CITY OF ALBUQUER

April 16, 2015

RE: **Chaparral Elementary School Portable Relocation** Grading and Drainage Plan Plan Dated 4-14-15 (File: F10-D005)

SHEET NO:
C-106R

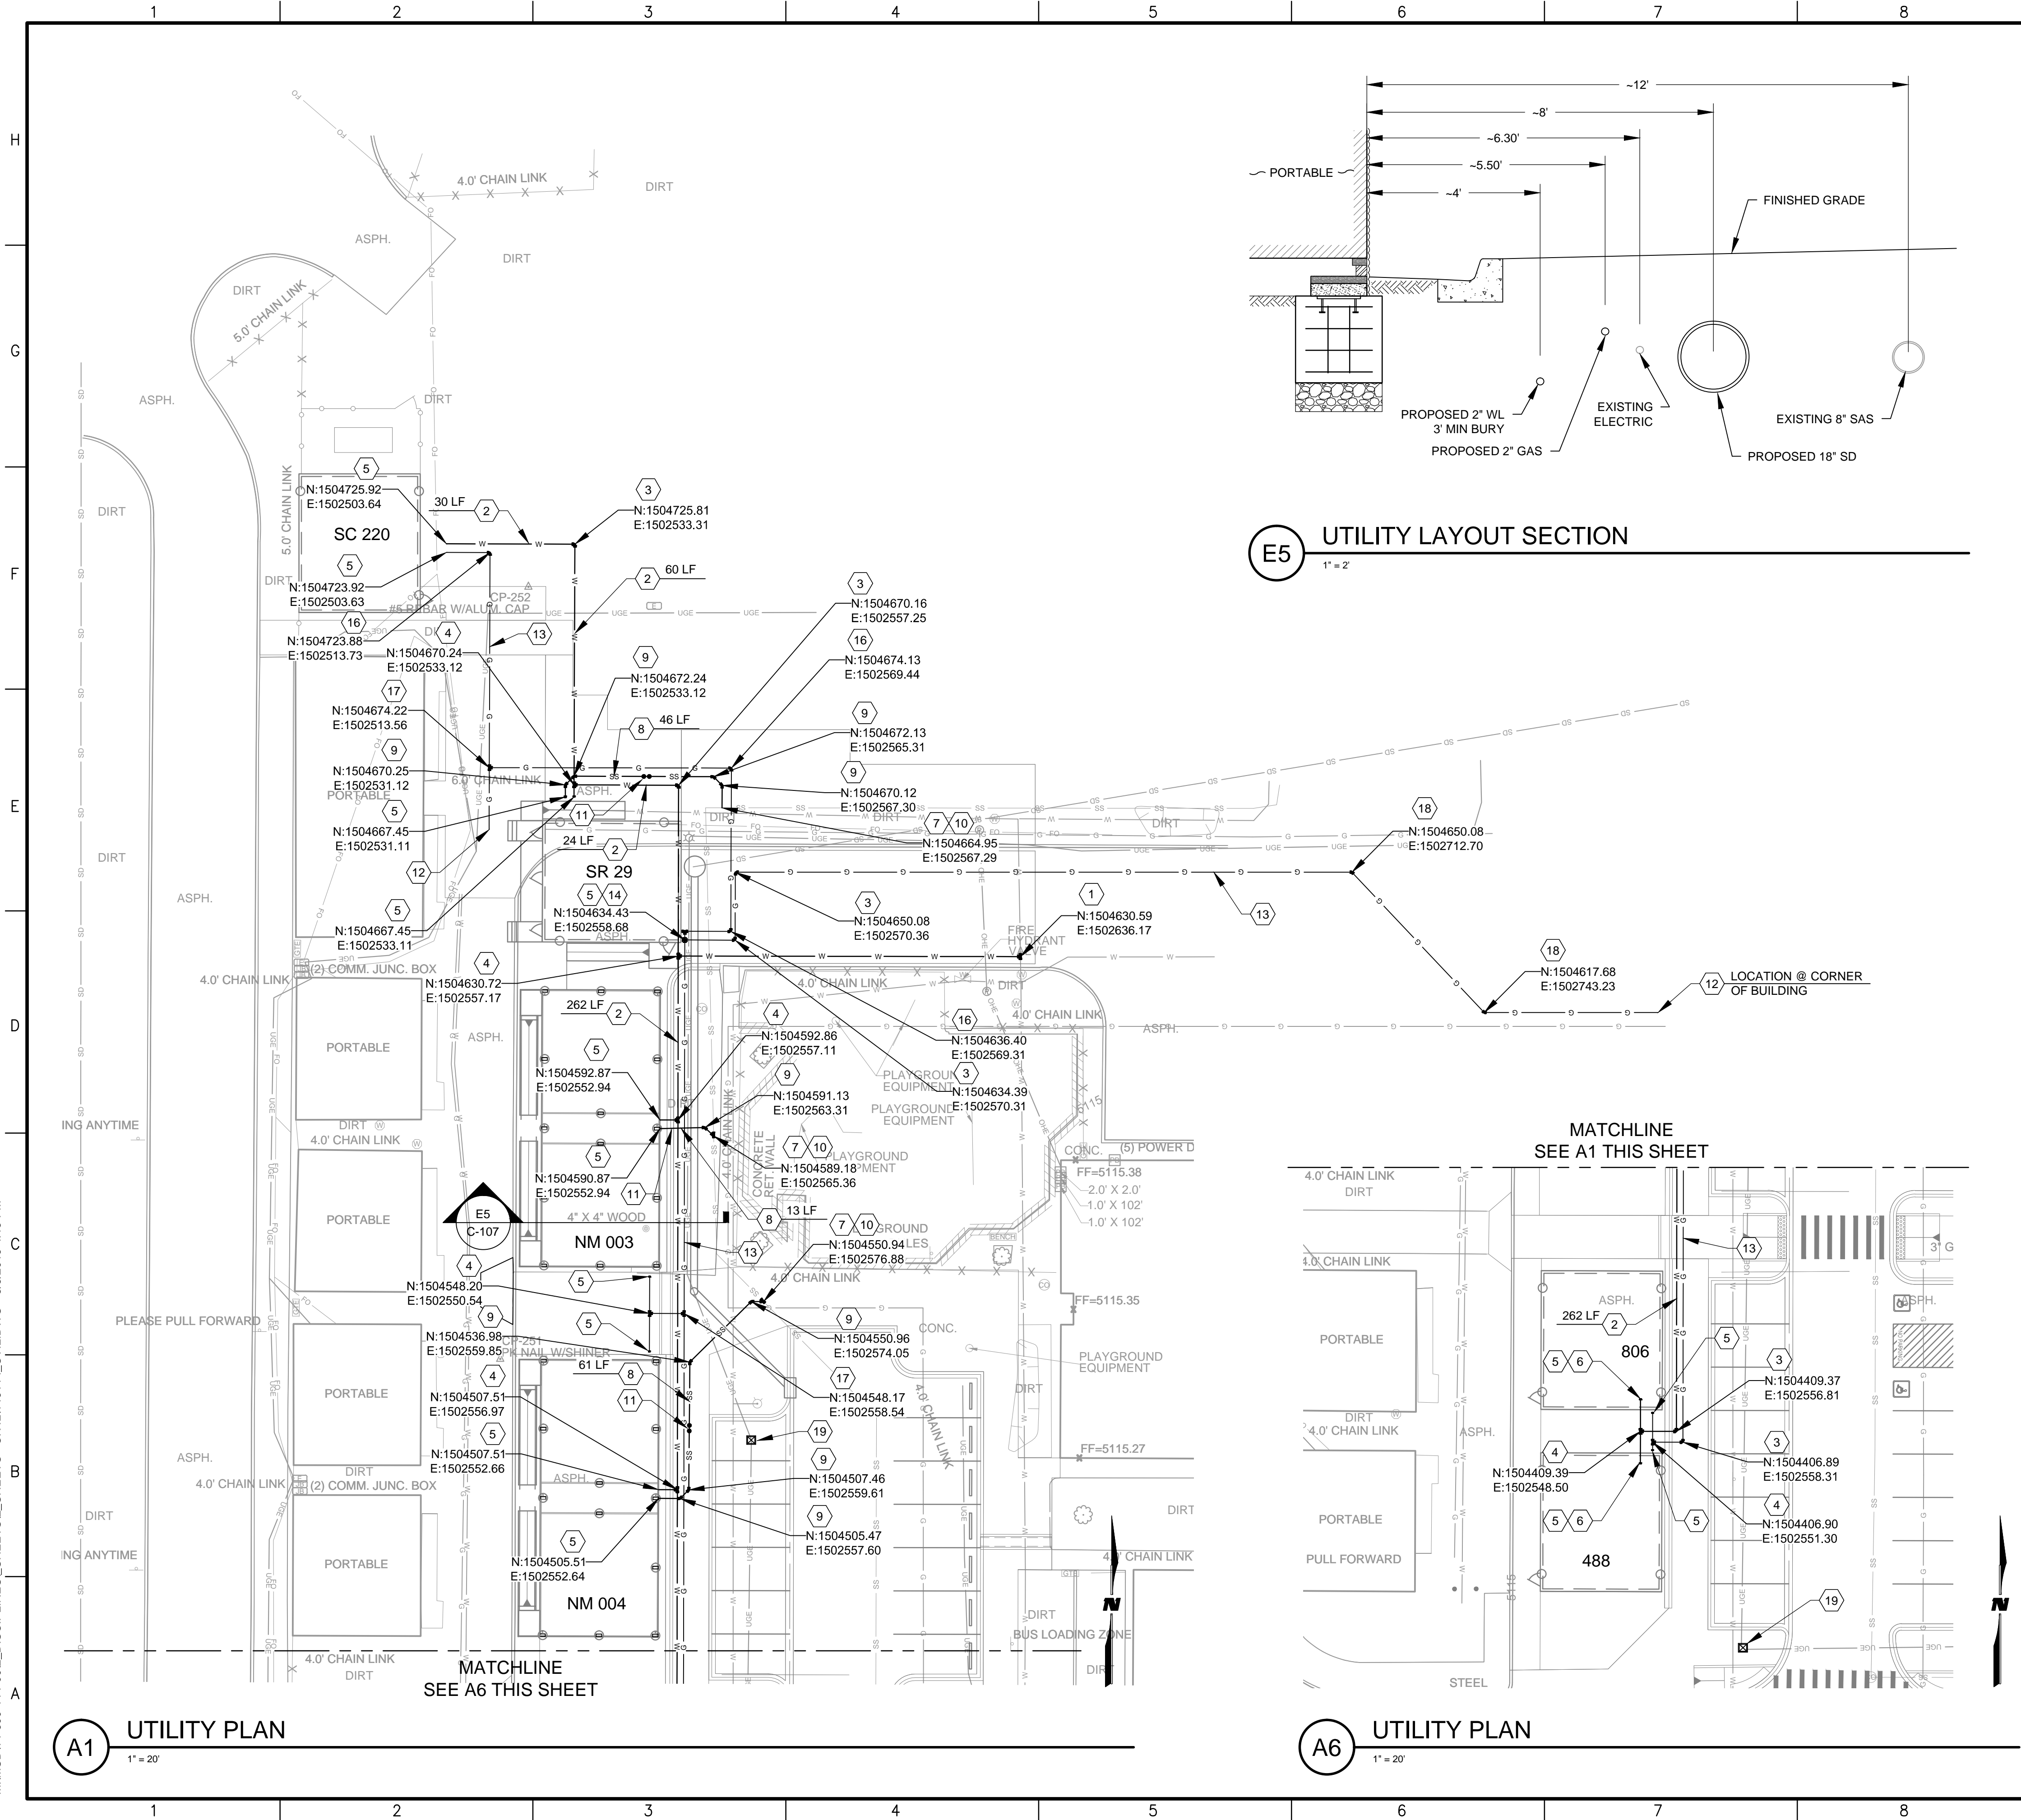
2) For all proposed pipe inlets and sidewalk culverts, show amount of flow that is captured and the capacity to handle the flow.

- 3) Label existing 18" storm drain pipe on the plan view and the proposed discharge of 11.94 cfs.
- 4) Show direction of runoff flow from the roofs of the portable buildings and any roof drains for the portable buildings. If there is any roof flow directed to the west of the New Mexico 87103 building, show how the flow is to be managed. Show how the roof flow for the three northernmost portable buildings is being managed and if it is being conveyed to the new on-site storm drain with additional information which may include additional spot elevations, and/or inlets.
